From: Sue Howell <Sue.Howell@arun.gov.uk>
Sent: 12 January 2022 16:57
To: Planning.Responses <Planning.Responses@arun.gov.uk>
Cc: Anita Gardner <Anita.Gardner@arun.gov.uk>
Subject: RE: Planning Consultation on: CM/69/21/PL

Application ref: CM/69/21/PL

Description: Flexible Generator Plant and associated infrastructure. This application is in CIL Zone 3 (zero rated) as other development and is a Departure from the Development Plan

Location: Land at Northwood Farm Yapton Road BN18 0HR

Drawing Title:
TIMBER ACOUSTIC FENCE

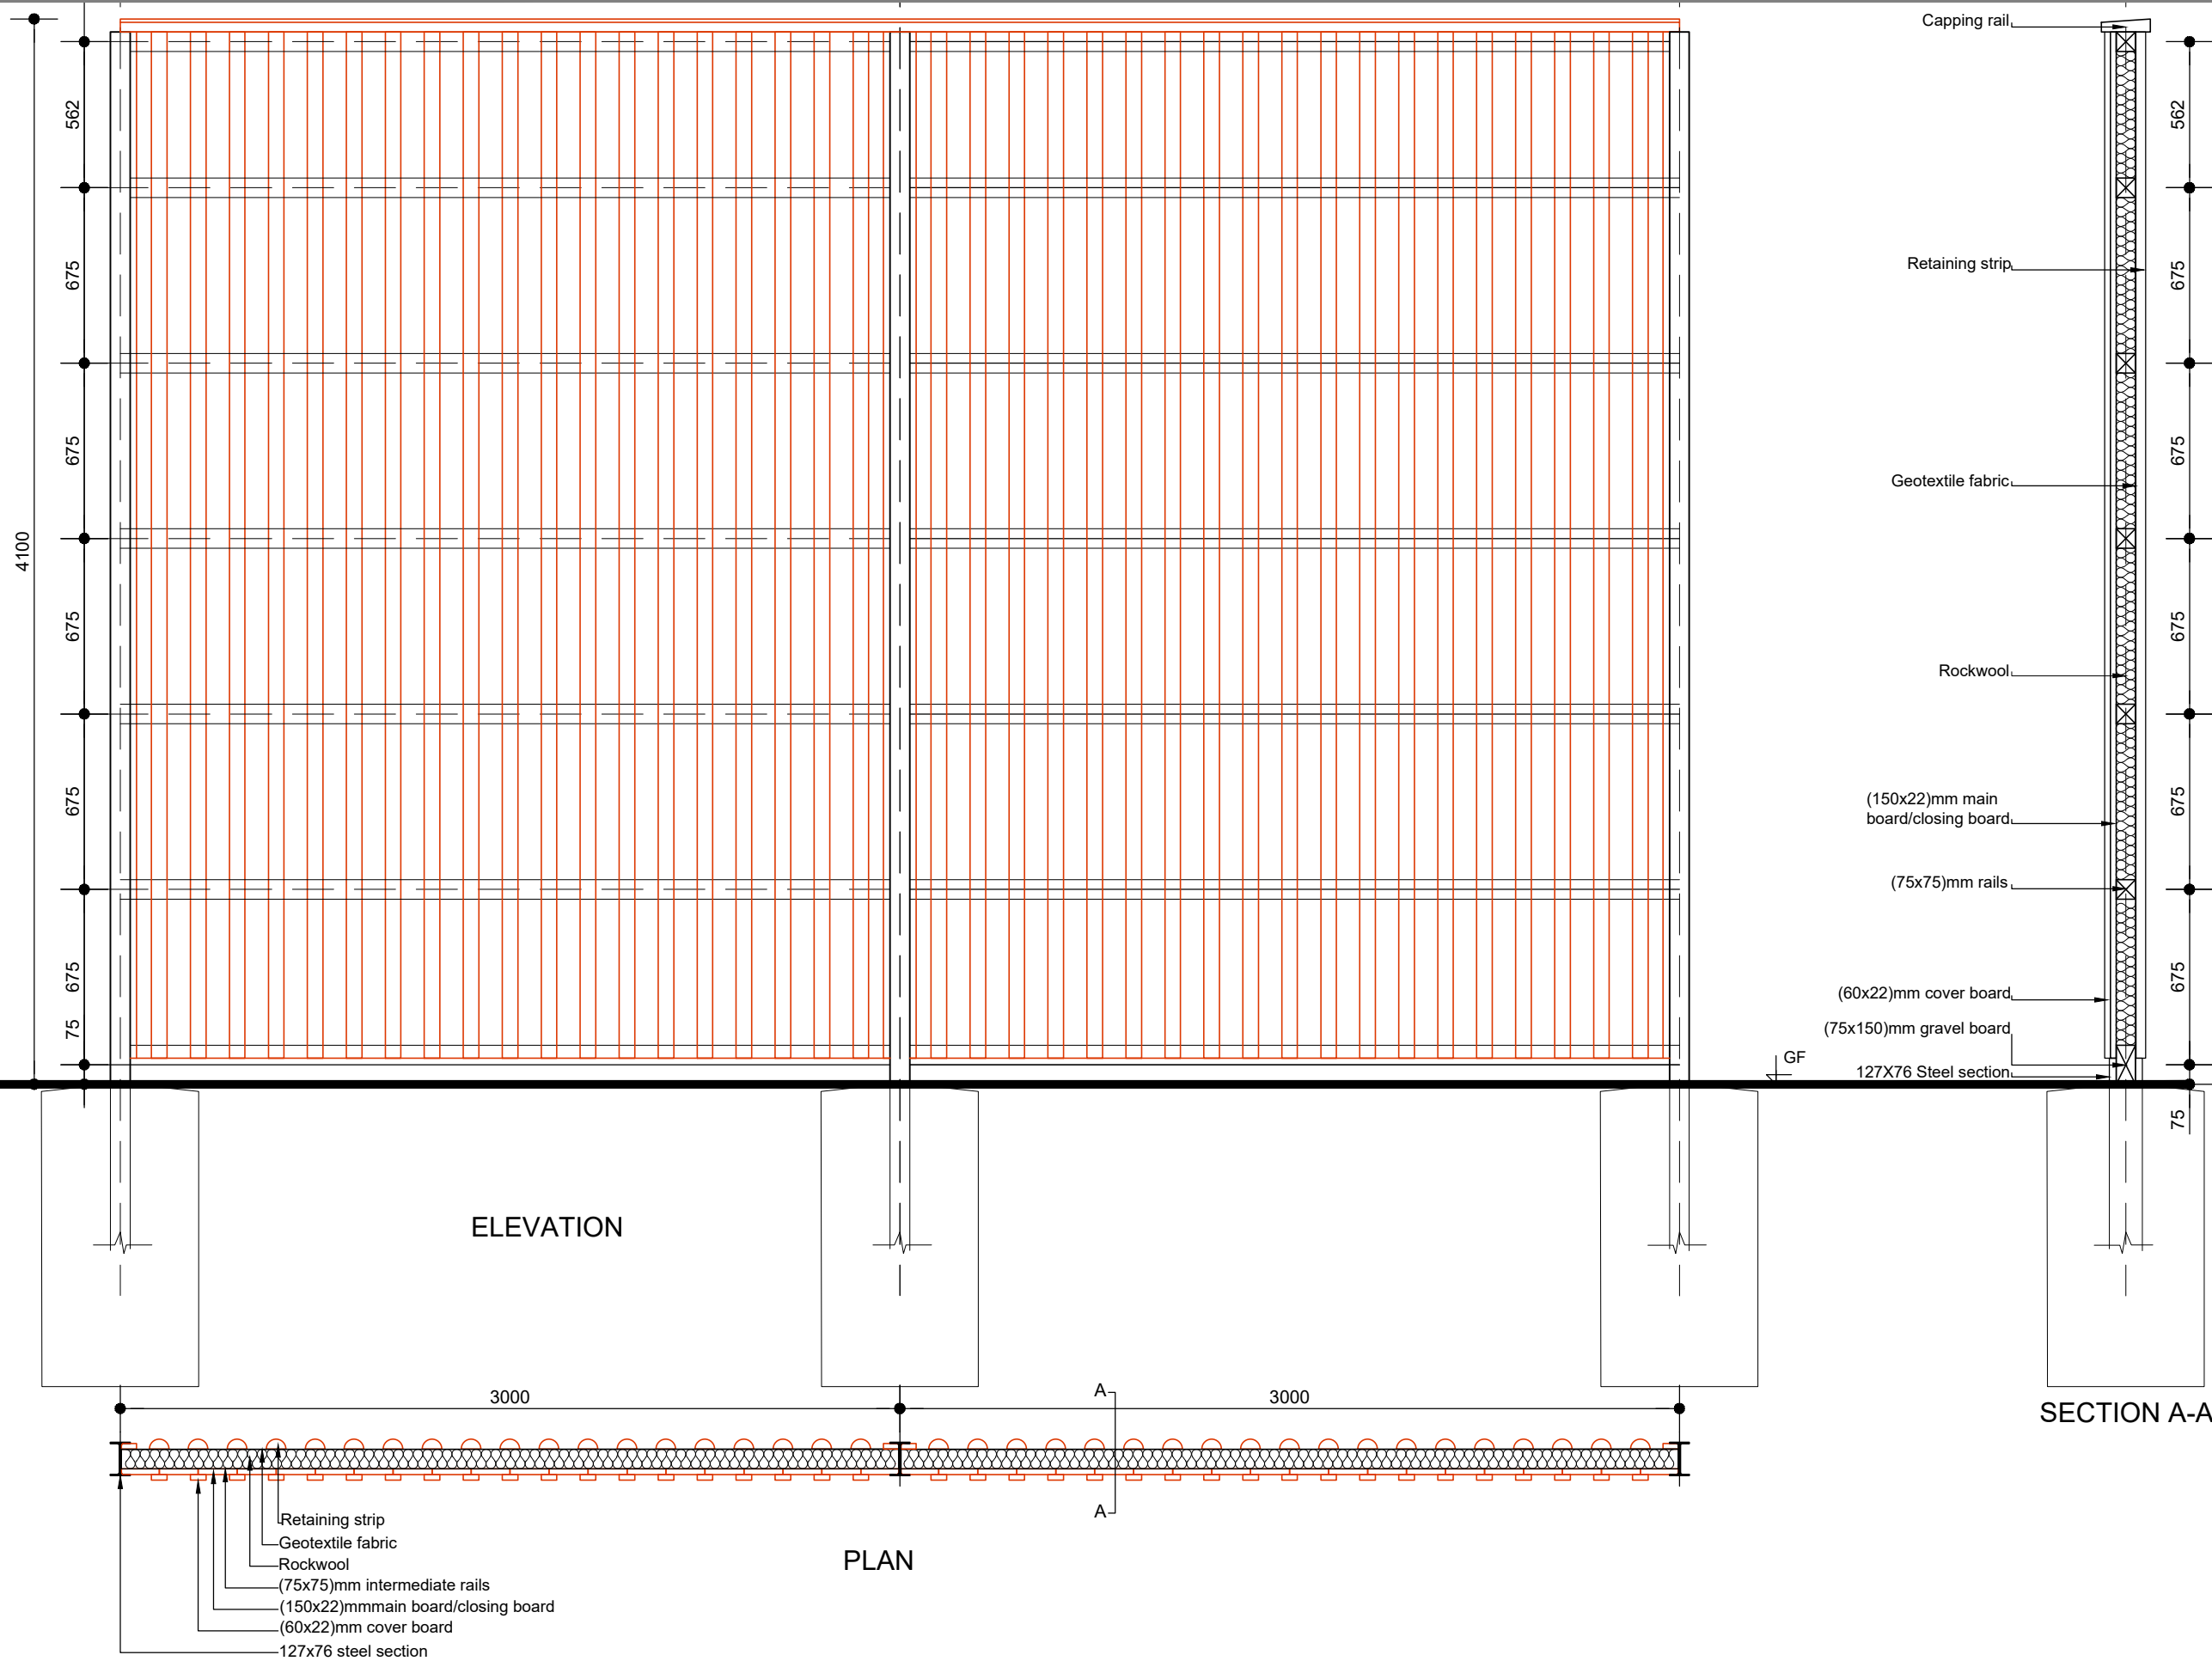
Indicative planting has been shown as mitigation for the development proposals however this information would need to be shown in greater detail including planting proposals with species, quantities and size detail. Detail has been included of a 4m acoustic fence to screen the proposals, this in itself would be intrusive on the landscape and significant and well thought out landscape mitigation would be needed in order to counteract this.

A full landscape scheme will need to be submitted for approval, or conditioned as part of any approval. This should be plotted in plan and list form and in relation to the trees and vegetation to be retained so that a clear picture of the proposals can be seen. The soft landscape proposals need to detail the actual quantities, species and size at time of planting and include additional screening as required to strengthen the boundary surrounding the proposals. Maintenance operations to be in place to ensure establishment of the proposed landscape scheme.
